# memorandum

date July 30, 2020  
to Lauren Anderson, City of Mercer Island, Planner  
from Jessica Redman, Wetland Ecologist  
subject 7511 92<sup>nd</sup> Avenue Patio Extension – Critical Areas Review

Figure 4. Proposed Buffer Averaging

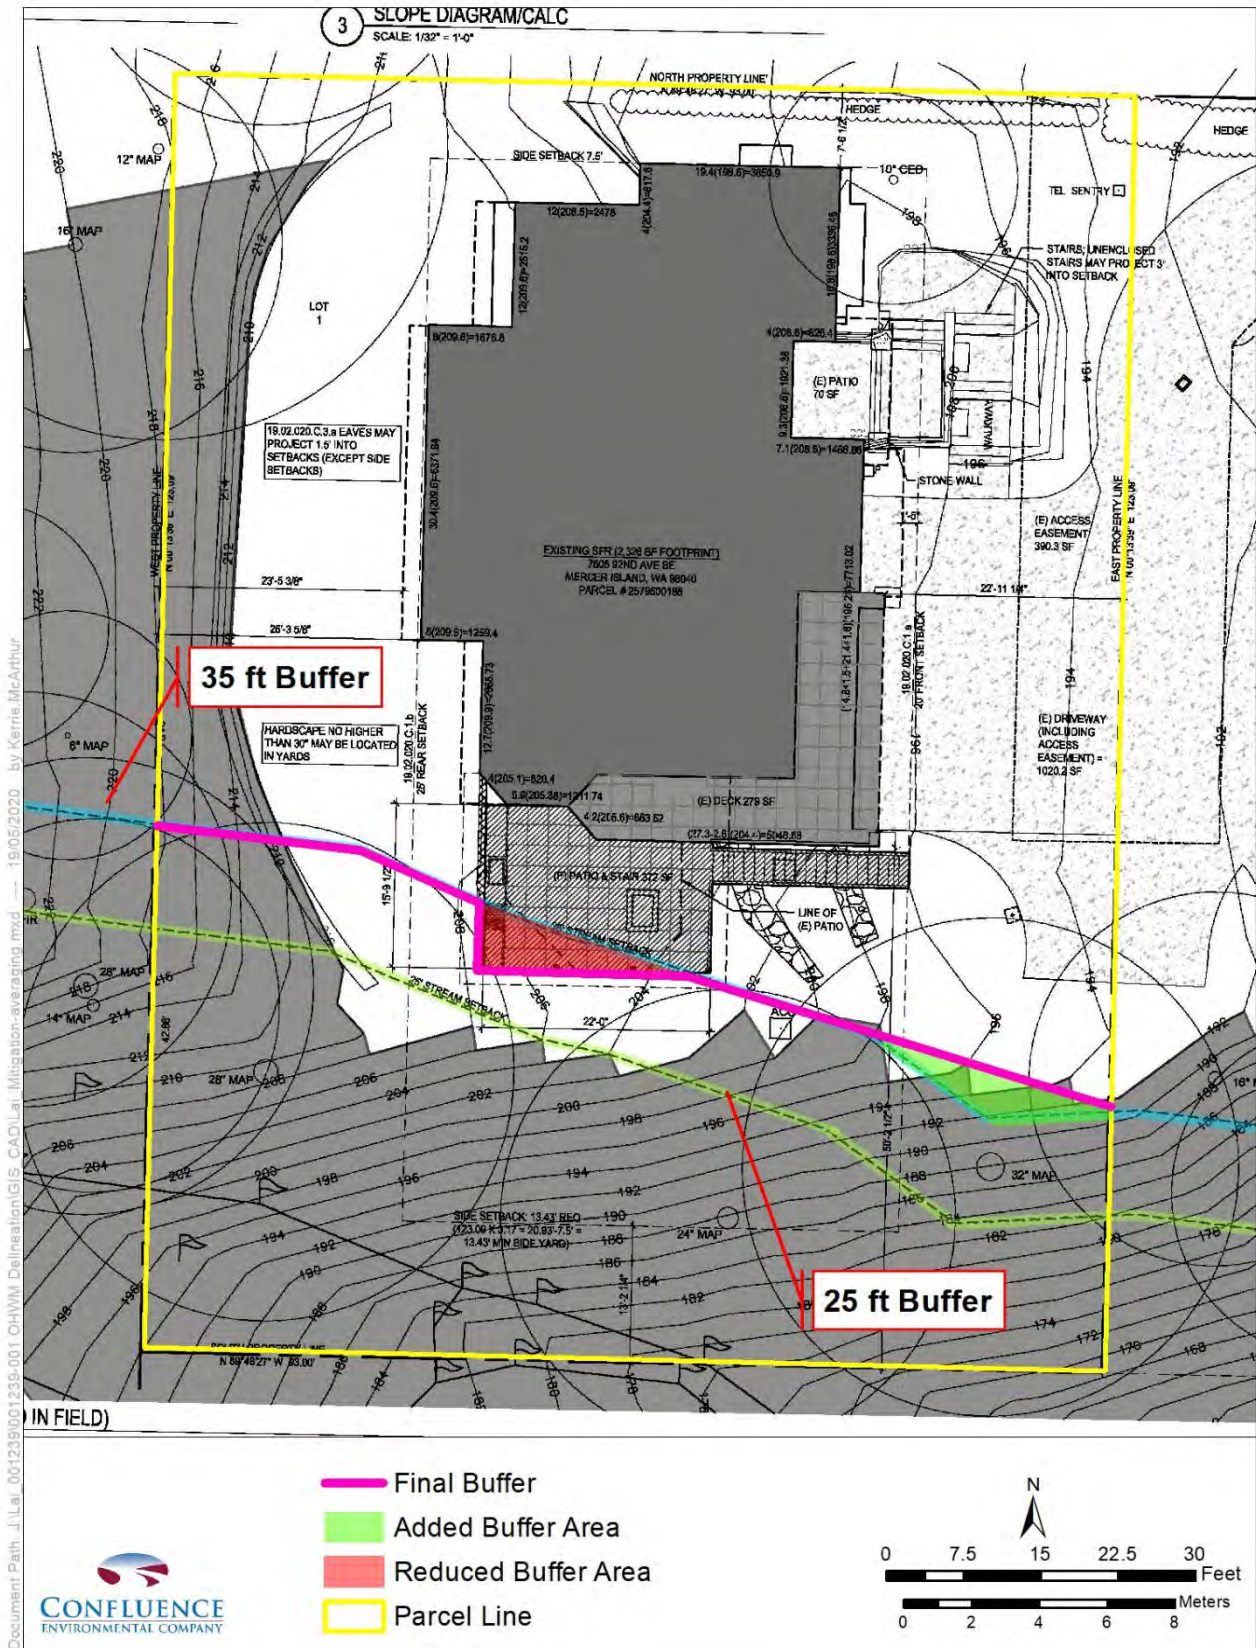
- ESA agrees that the proposed Project has met all the requirements for buffer averaging per MICC 19.07.070.3 and MICC 19.07.080.3. The applicant has proposed a combination of wetland and stream buffer averaging by reducing the wetland buffer and increasing the adjacent stream buffer. However, due to the large area of the onsite buffer proposed for enhancement post-construction, ESA agrees the project will result in an ecological lift through the reduction of invasive species and installation of native trees. Therefore, the proposed buffer averaging will not result in a net loss of buffer function or area.
